## Rezoning Petition Review

**Date of Review:** May 20, 2020 (**Revised June 19, 2020**)

**Rezoning Petition #:** 20-55

**Location of Property:** Approximately 27.97 acres located along the east side of IBM Drive, west of I-85 and south of West WT Harris Blvd.

SHEET NUMBER **RZ-1**

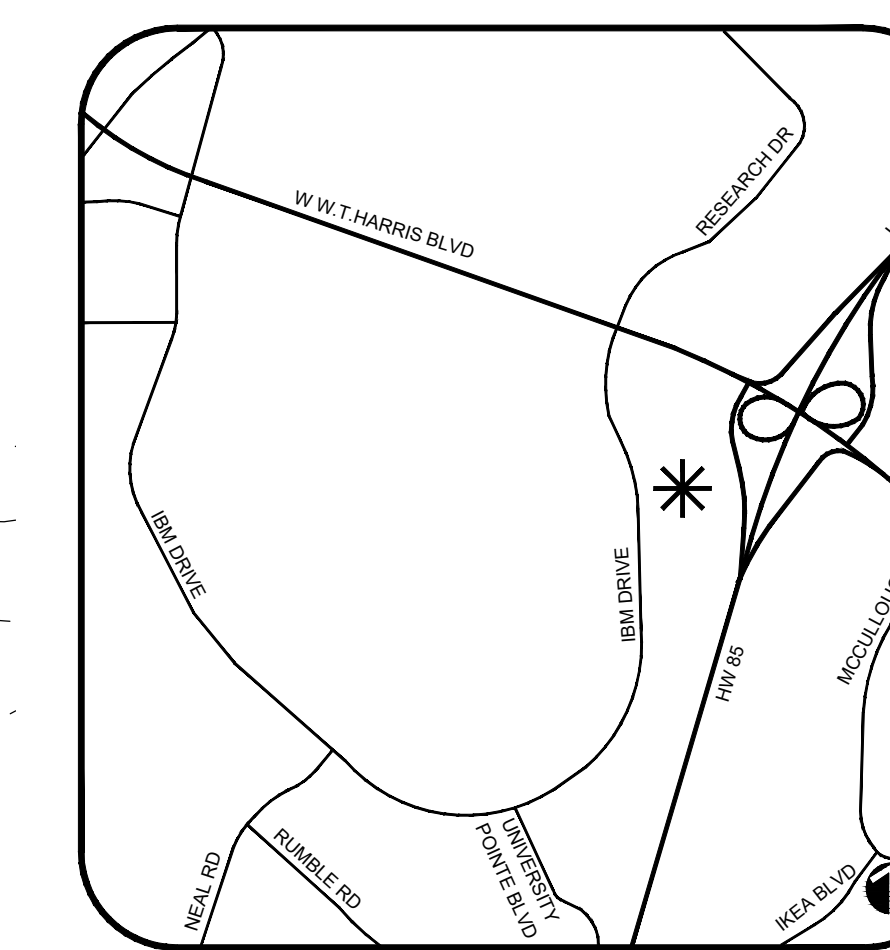
**Concerning Storm Water:** Plan sheet RZ-1 indicates a 100-ft SWIM Buffer on site. Please revise buffer label to read "100-ft SWIM/Undisturbed PCSO Buffer."

Plan sheet RZ-1 indicates a drainage feature adjacent to Building Envelope #4. Please note any intermittent or perennial streams in this watershed require a PCSO Buffer. Please include the following note under *Environmental Features: Development within the SWIM/PCSO Buffer shall be coordinated with and subject to approval by Charlotte-Mecklenburg Storm Water Services and mitigated if required by City ordinance. Stream Delineation Reports are subject to review and approval by Charlotte Storm Water Services.*
